Department of Planning, Housing and Infrastructure

Our ref: Mixed Use Development Bells Boulevard Kingscliff (SSD-83069459)

Subject: Request for Information

Appendix A

Neighbouring Properties: Solar ADG Minimum

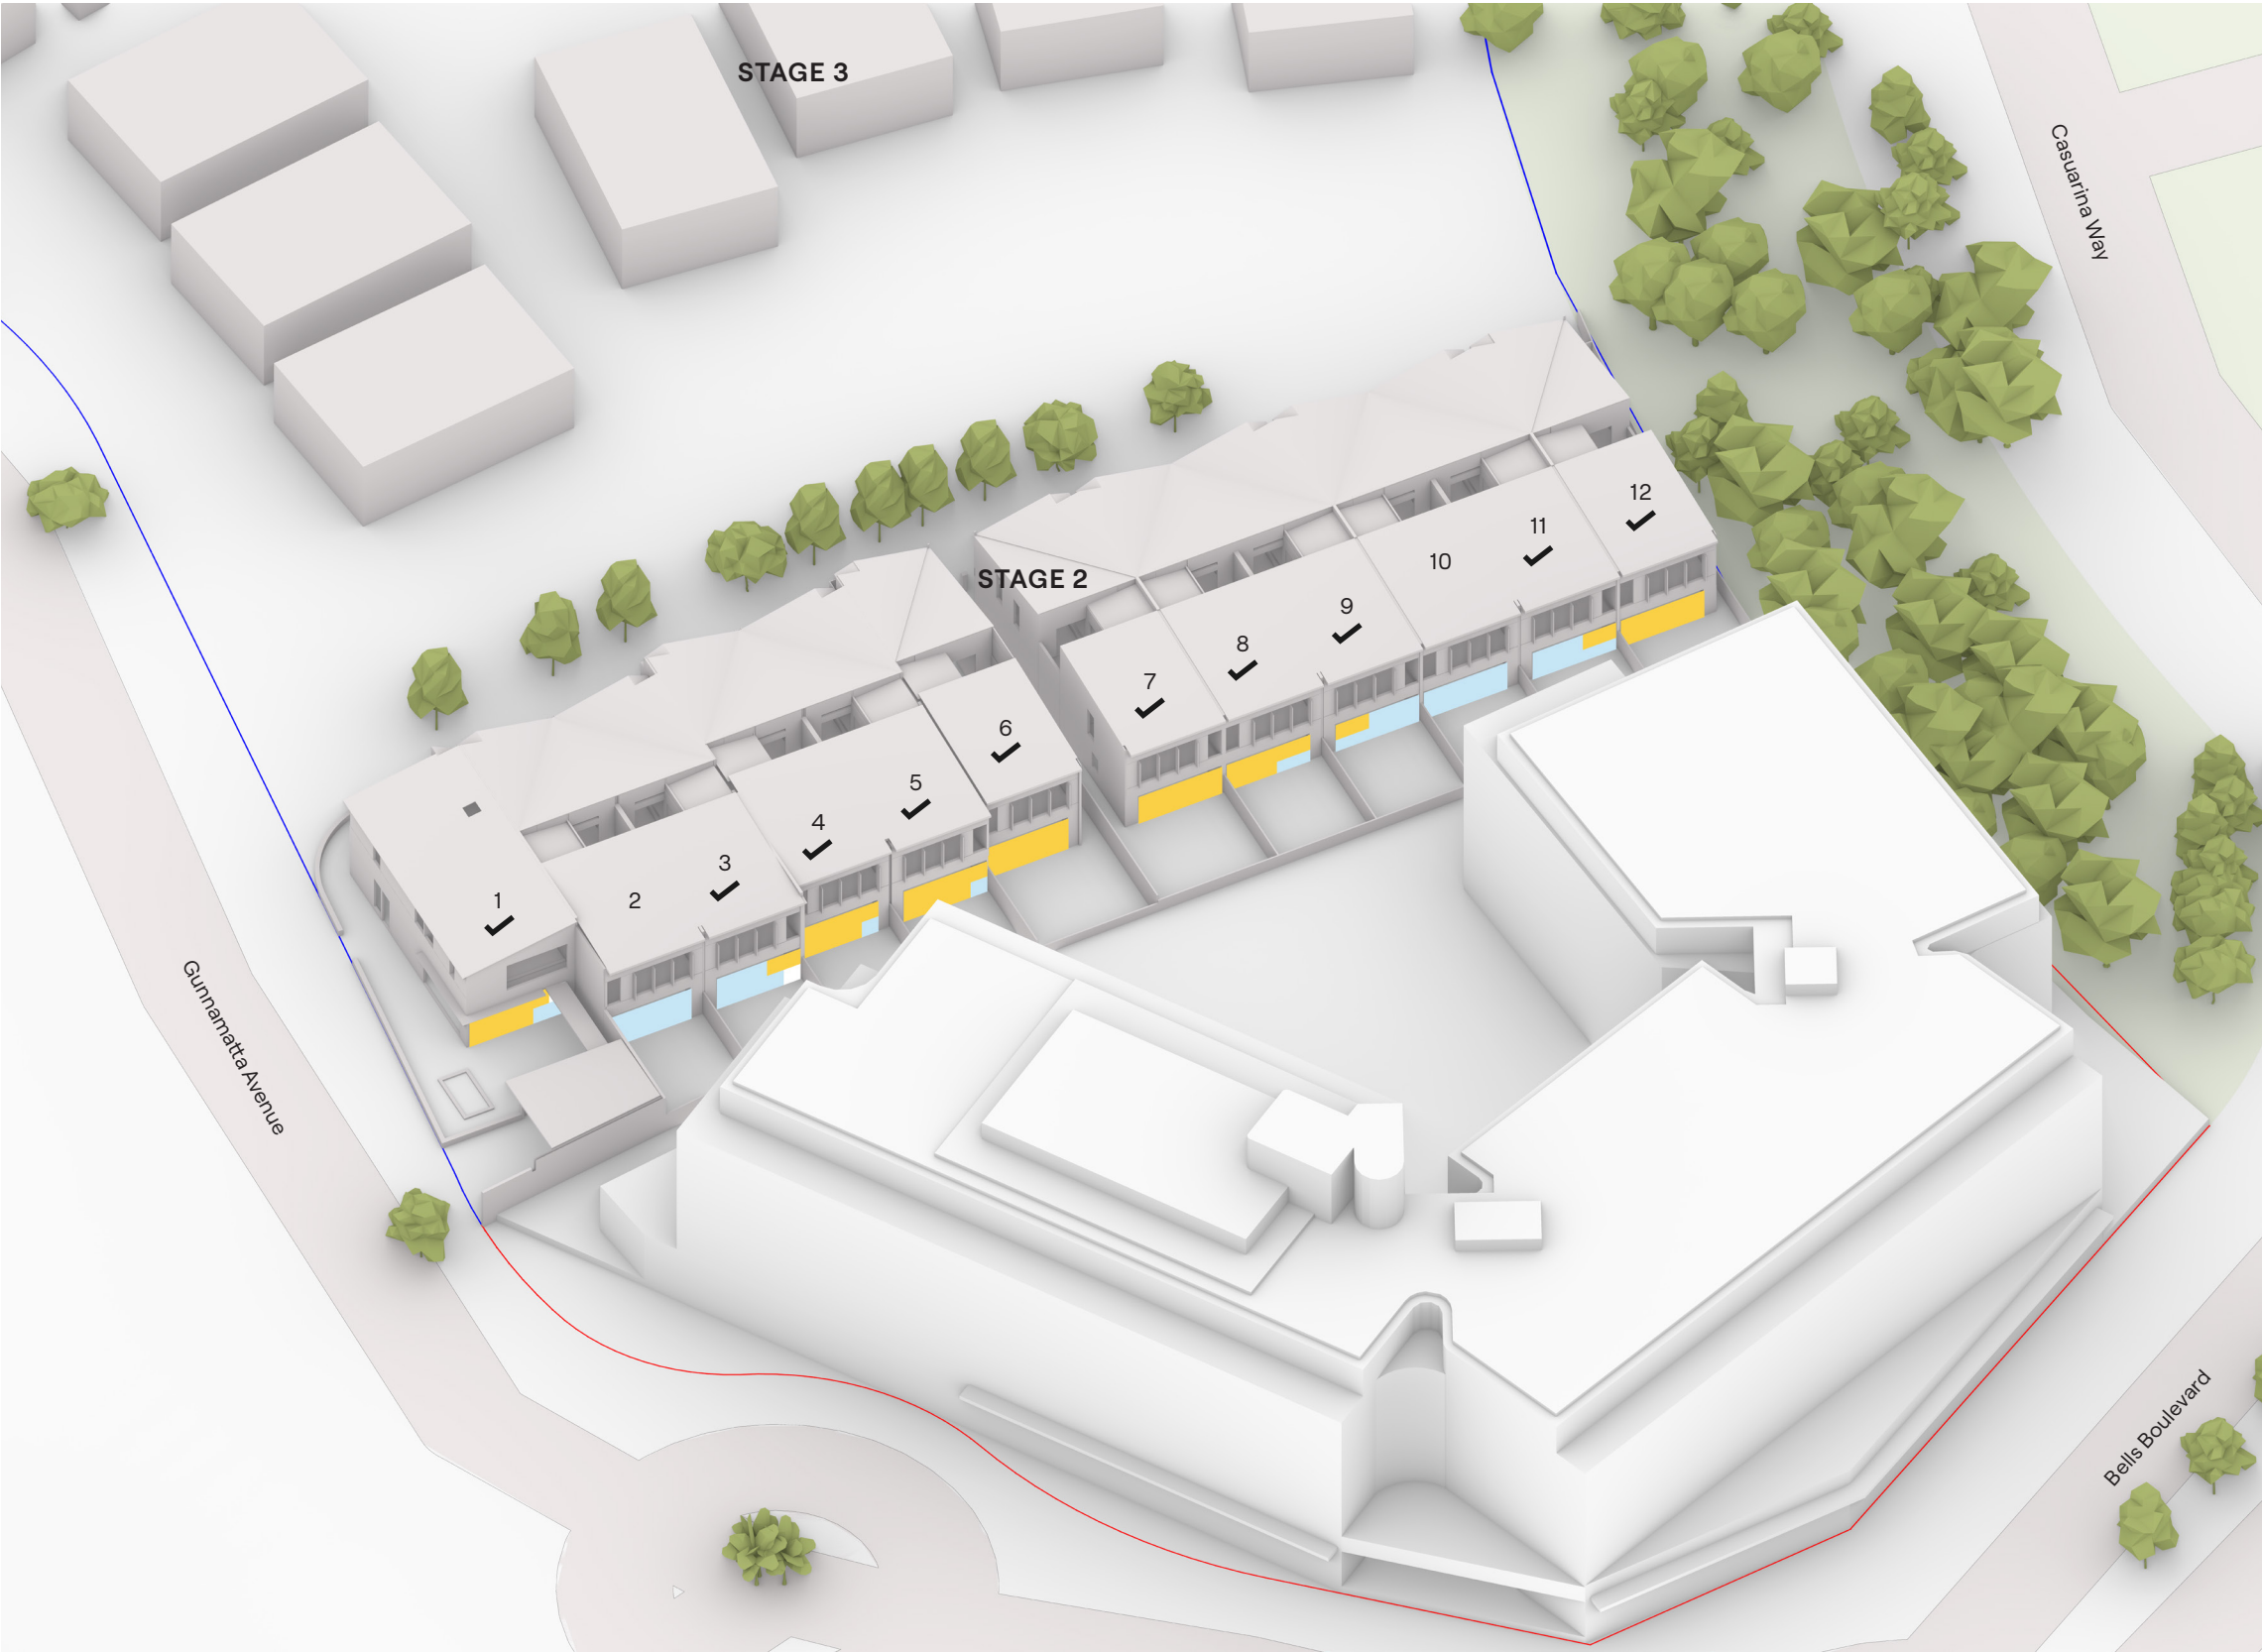
The solar study is required to be revised to demonstrate the impact to the townhouses to the south based on the requirement for at least three hours direct sunlight between 9am and 3pm at mid-winter. Consideration is to be given to improving solar access to the communal open space area.

FIGURE 2: DRIVEWAY SIGHTLINE ASSESSMENT – FOR 85TH PERCENTILE SPEED

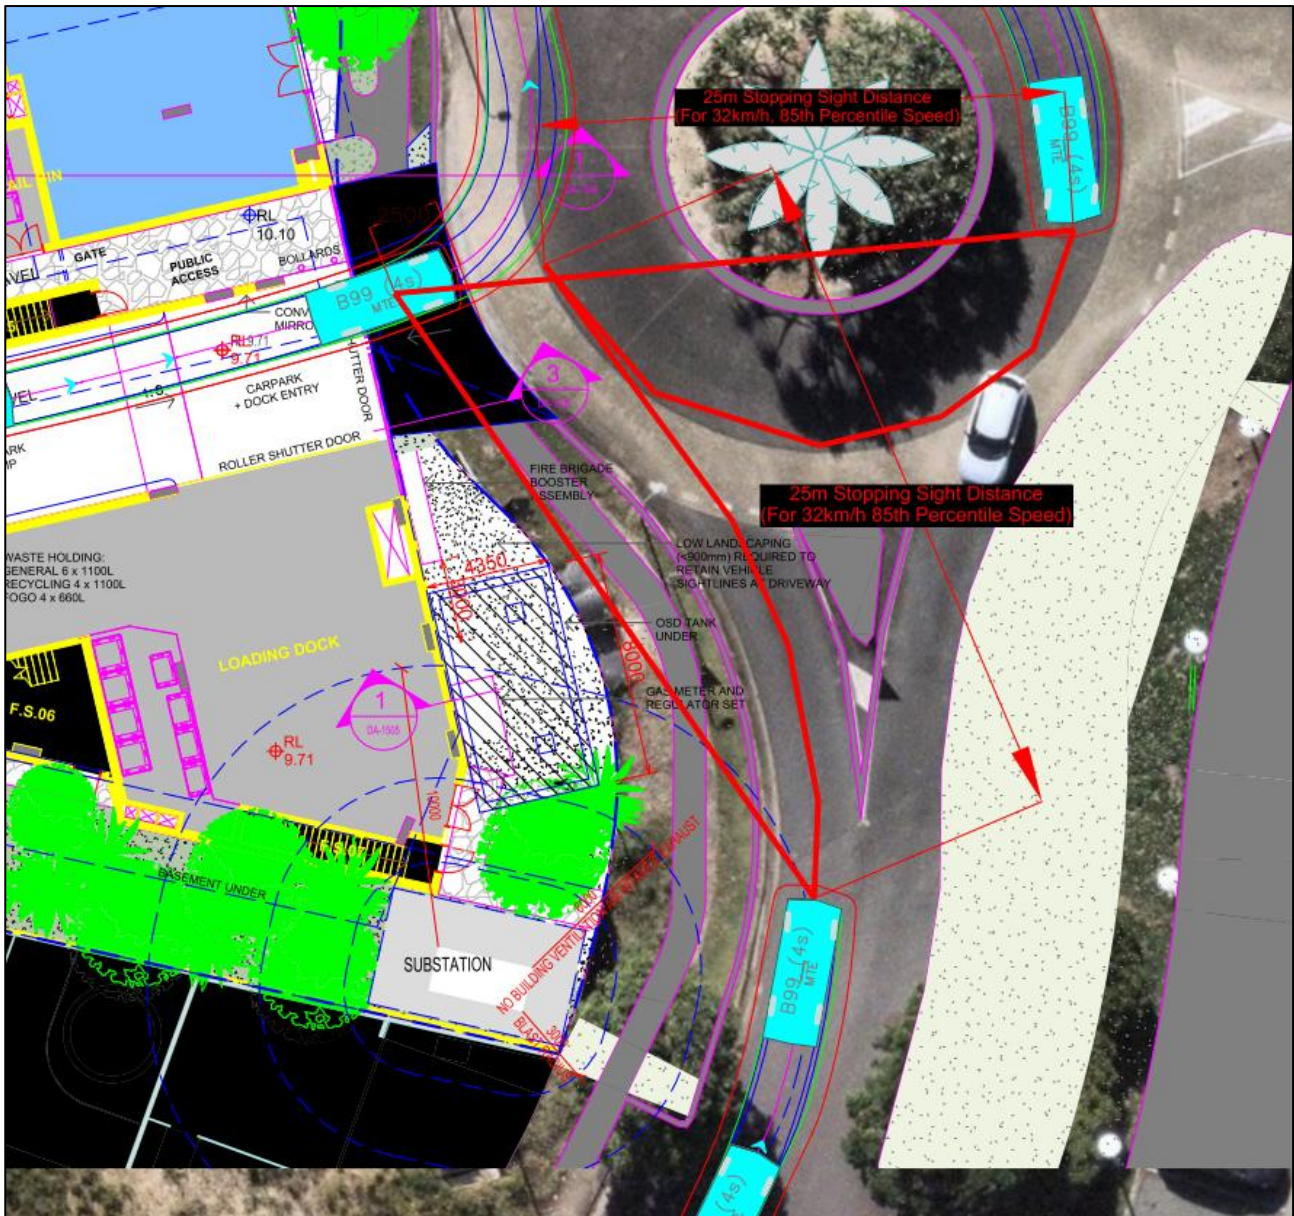
The current position and configuration of the driveway present potential road safety risks. The safe operation of a roundabout relies on adequate sight lines, and both the adjacent building structure and driveway grades significantly restrict visibility. The driveway is also partially concealed, making its location less intuitive for approaching drivers. The requirement for waste collection vehicles to negotiate movements with exiting traffic further increases the likelihood of vehicle movement conflict.

The Department requires you to engage an independent road safety auditor to undertake a Road Safety Audit (RSA) to assess the safety implications of the proposed access and associated design features and to demonstrate that appropriate due diligence has been exercised, and potential safety risks have been independently reviewed and formally considered.

2 SECTION_OVERLOOKING STUDY
DA-1002 SCALE 1:100

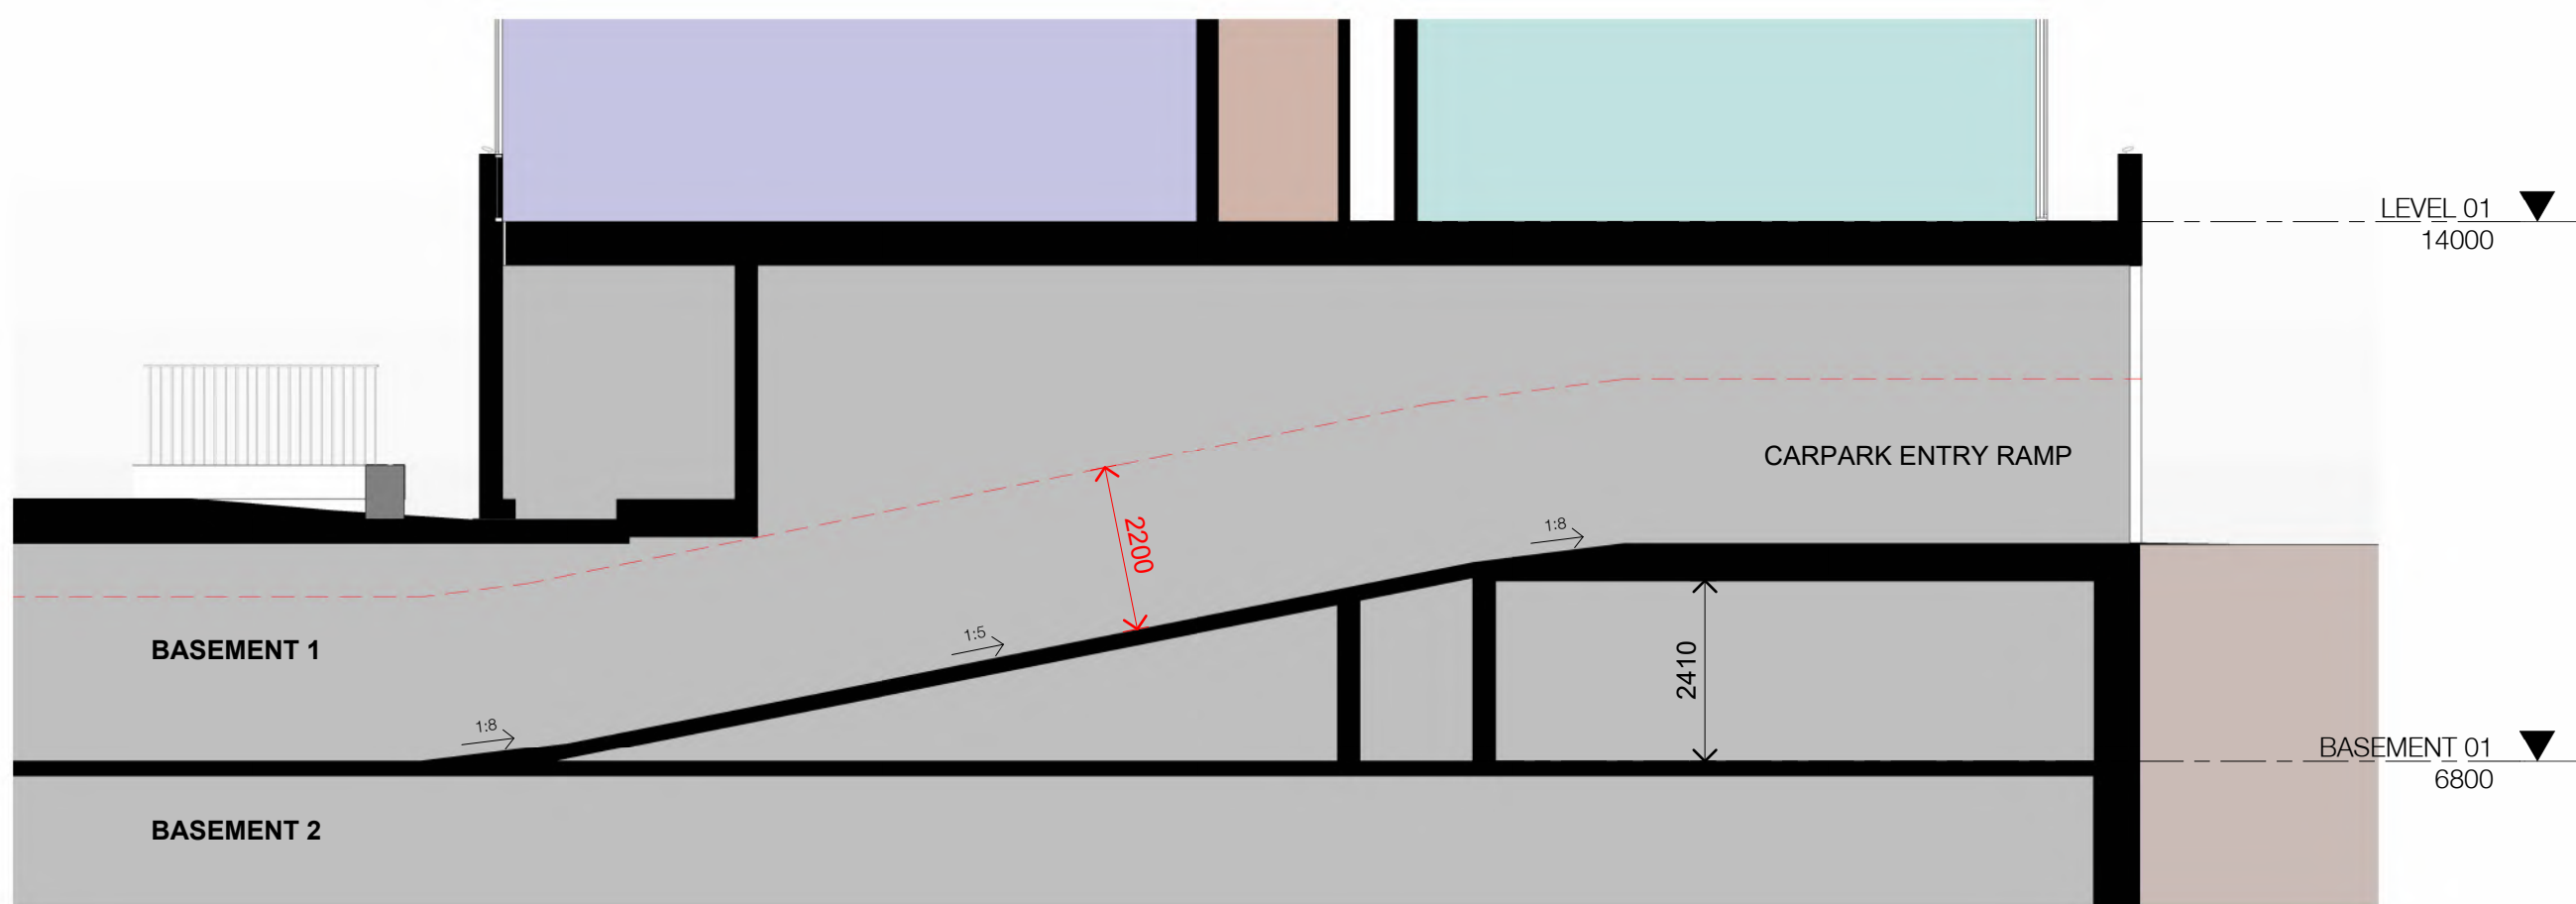
There is potential for privacy impacts to the ground floor units from the communal open space and overlooking of the approved townhouses to the south. Further detail is required to demonstrate the proposal has incorporated appropriate privacy mitigation measures. The consolidated RTS/RFI response needs to address issues raised in the submission provided by Tweed Shire Council.
